PORTLAND MAINE

November 18, 2009

Re: 12 Tarbell Street – 332 E038 – R-3 – 16' x 20' single story addition – permit #09-1235

<b>PLOT PLAN</b>	
SCALE: 1/4" = 1'	APPROVED BY:
DATE: OCT 29 09	DRAWN BY: JUDY ALLEN/AS
BEDROOM ADDITION 16X20	
OWNER: GREGORY GAY 12 TARBELL ST	
PARL AND 318	
DRAWING NUMBER	I

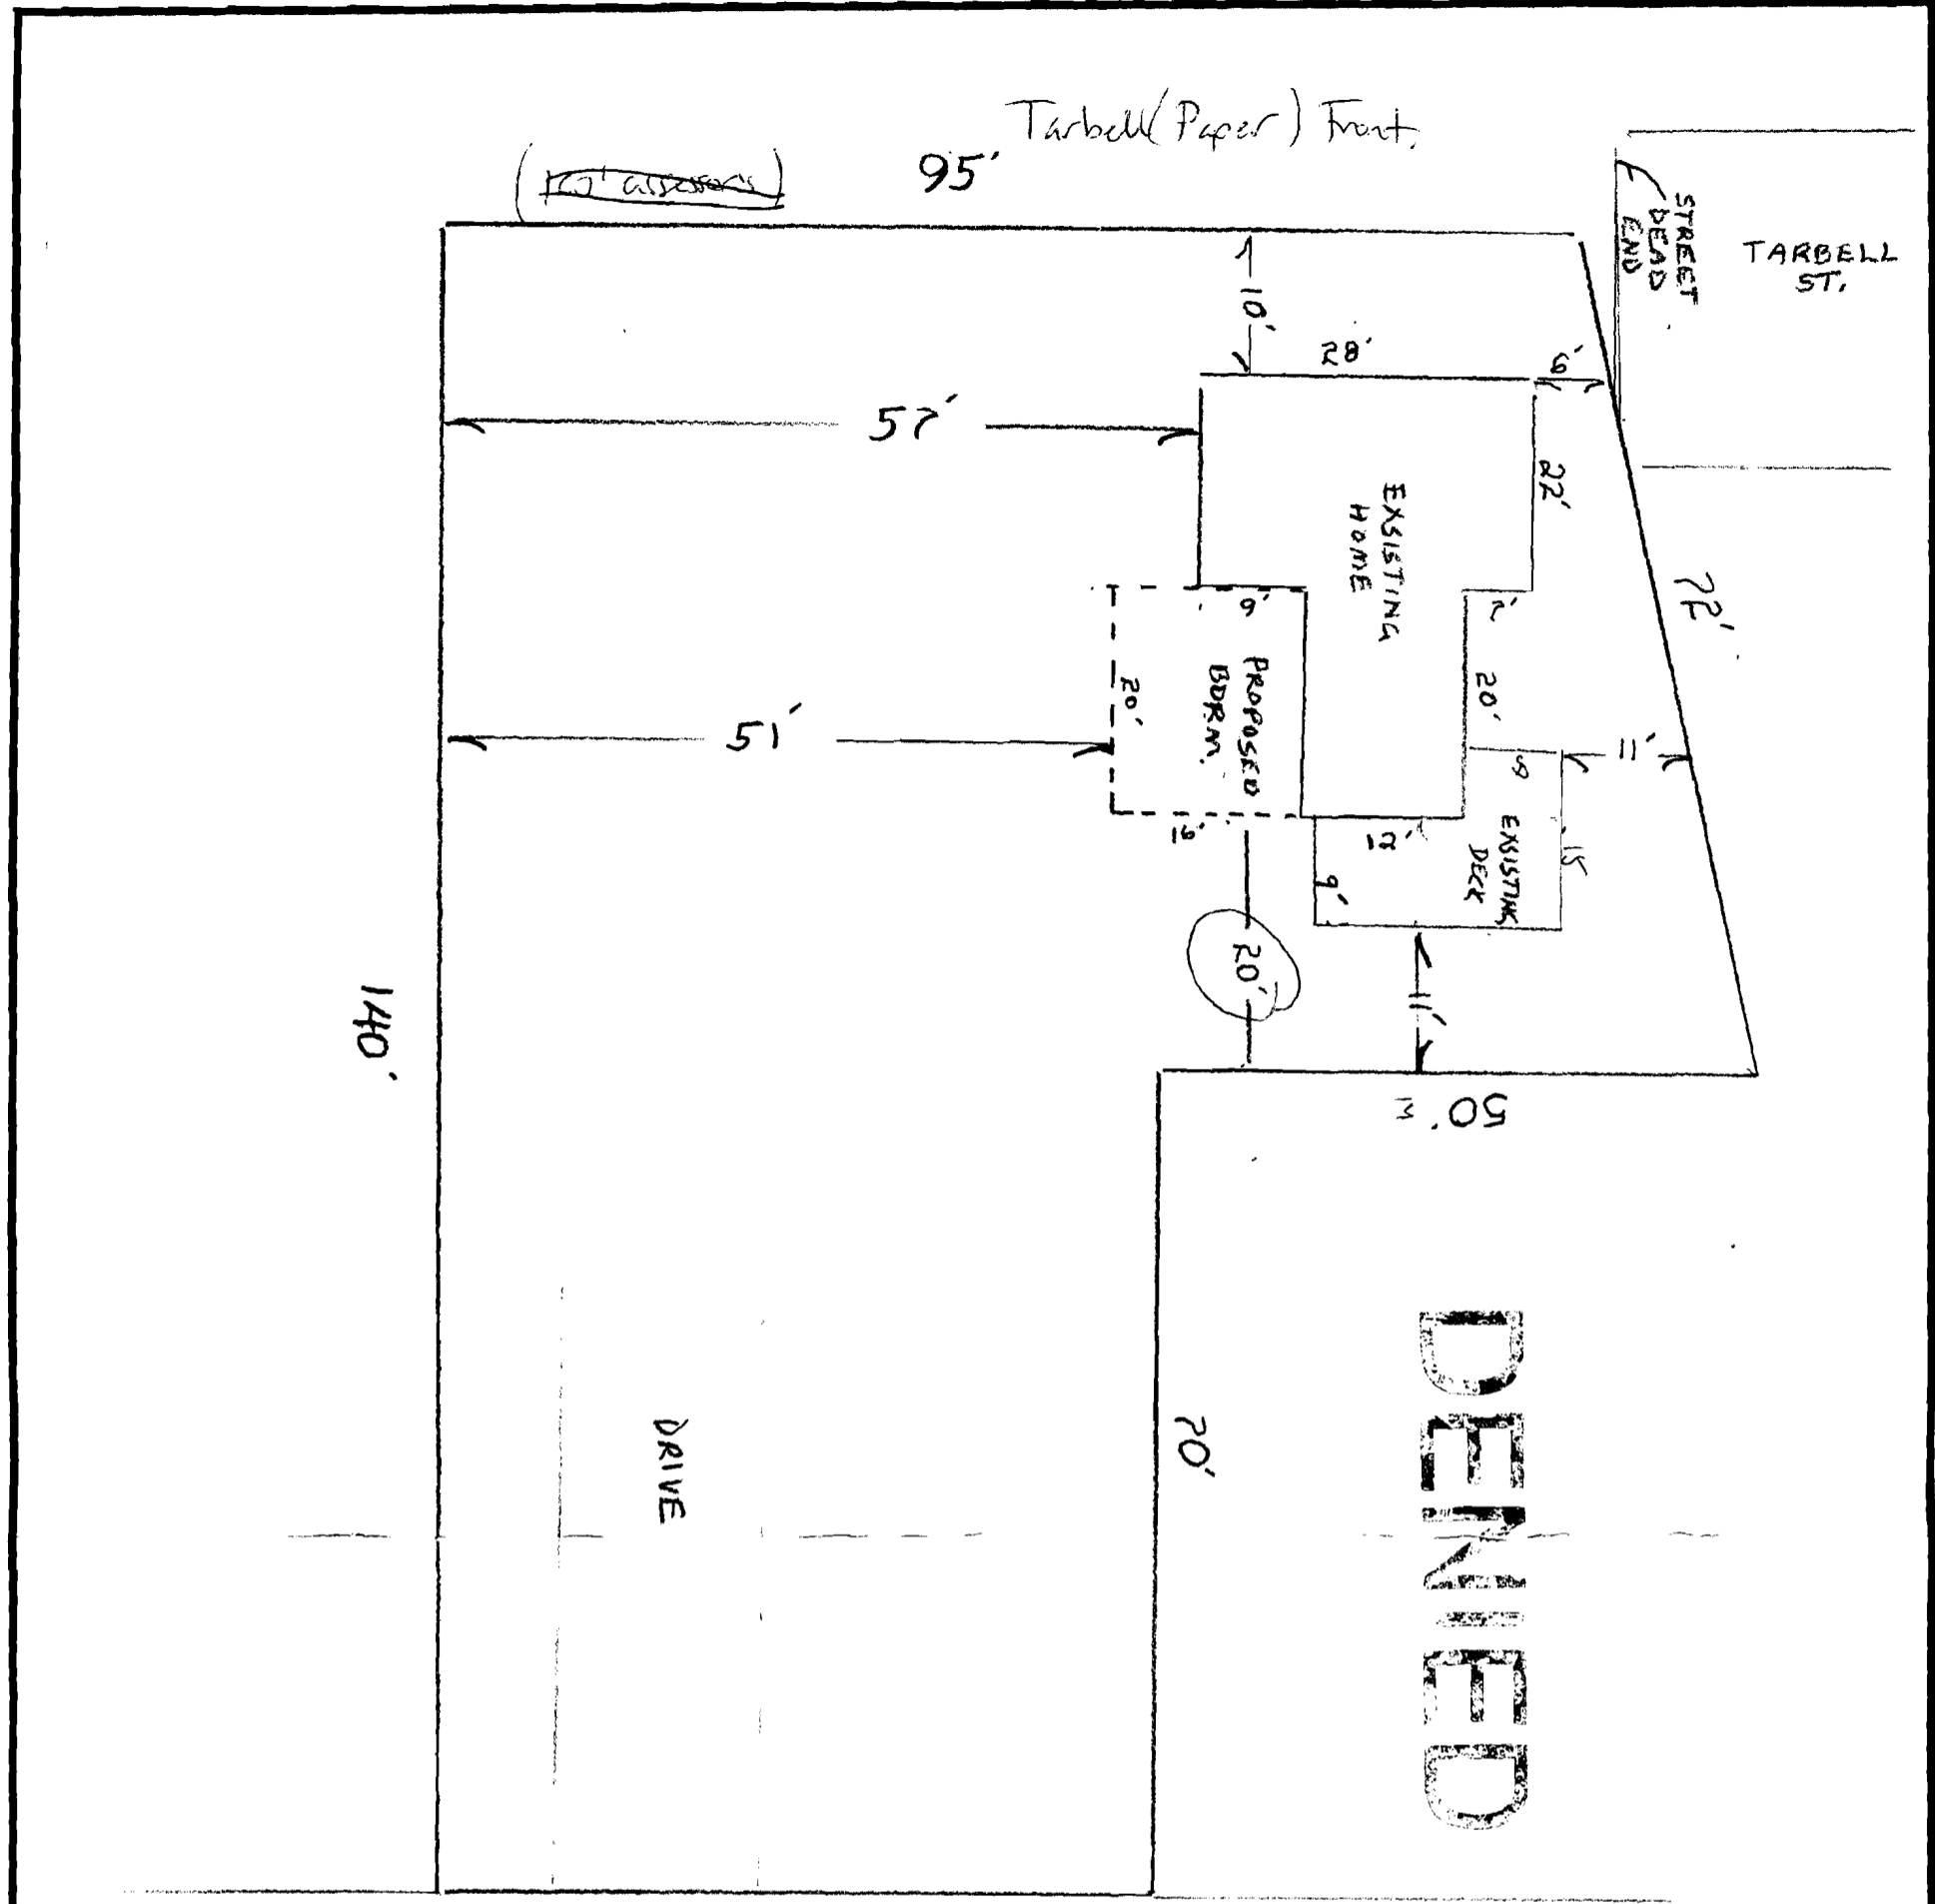
12 Tarbell Street is located in the R-3 residential zone. The required rear setback in the zone is twenty-five feet [Section 14-90(d)(2)]. The plot plan shows the rear setback to the proposed addition as twenty feet. Since it does not meet the required setback, the permit is denied.

In reviewing the permit application, it came to my attention that the existing deck on the rear of the house has never been permitted. We have no record in our system for a deck having been built. When we cannot find a permit for a structure, we default to the pre-1957 assessor's record. The pre-1957 assessor's record shows a six by twenty foot deck on the left rear side, but not the deck that exists now. Since the existing deck was not built before 1957 and there is no record of it being permitted, it is illegal.

The property must be brought into compliance. Since the setback for the existing deck does not meet the required twenty-five foot rear setback, it cannot be permitted after the fact. Since it cannot be permitted, it must be removed. You have thirty days from the date of this letter to remove the deck.
